Harnett County Government Complex
307 Cornelius Harnett Boulevard
Lillington, NC 27546

April 12, 2005

Re: Status of Improvement Permit Application #05-5-11751

HTE 05-5001 1751R

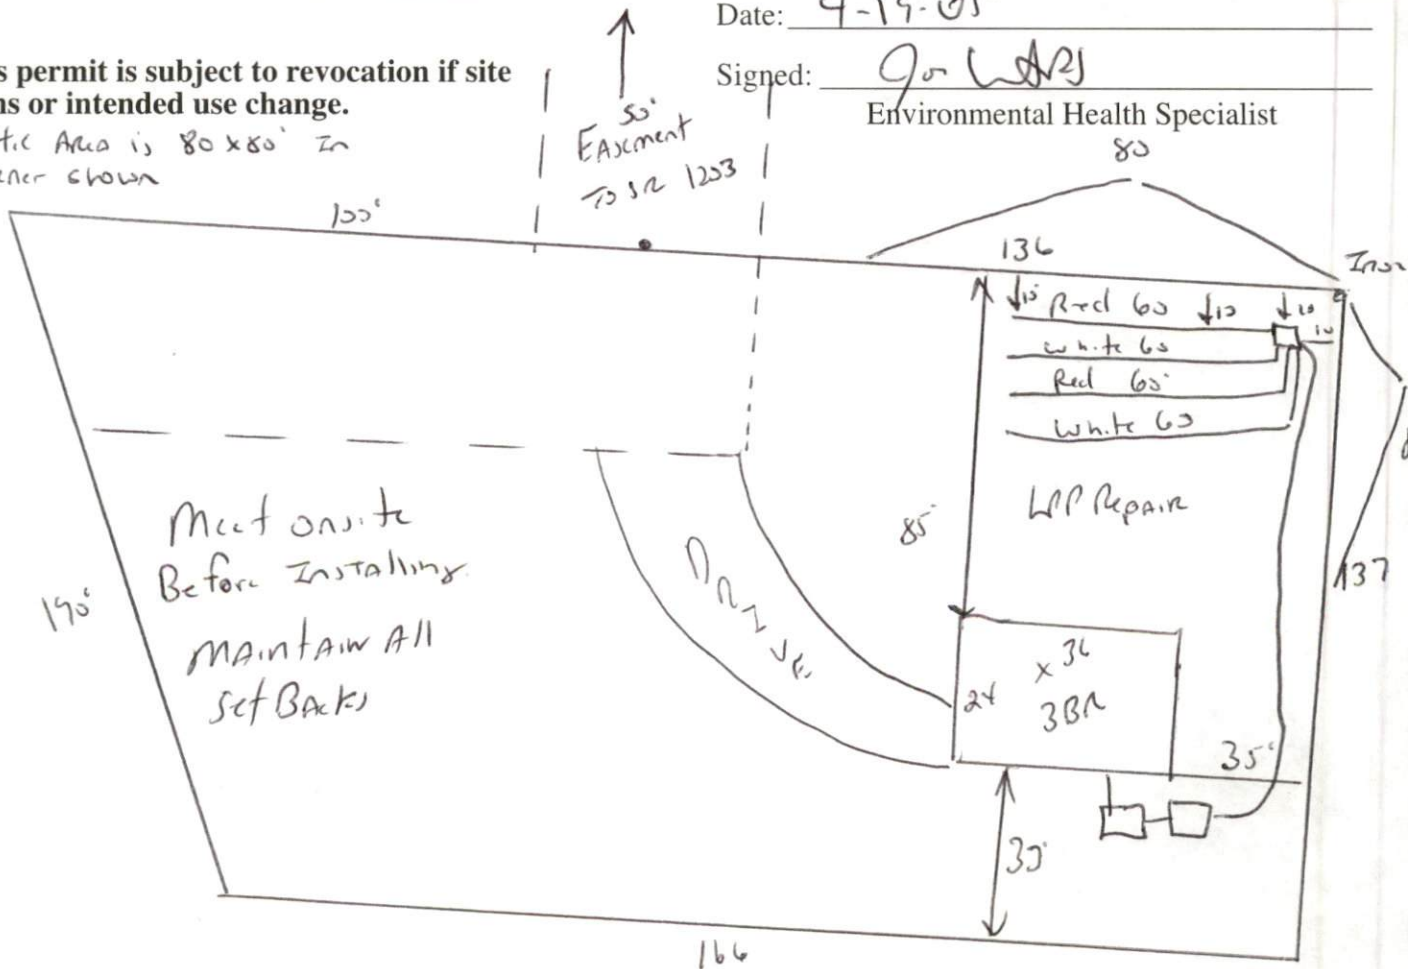
- 1. Property lines/corners not marked or labeled
- 2. House corners not marked or labeled
- 3. Directions not clear to property
- 4. Property needs brush or vegetation removed
- 5. Backhoe pits required
- 6. Other **Move house location so that it is not in the area shown for septic system and repair.**
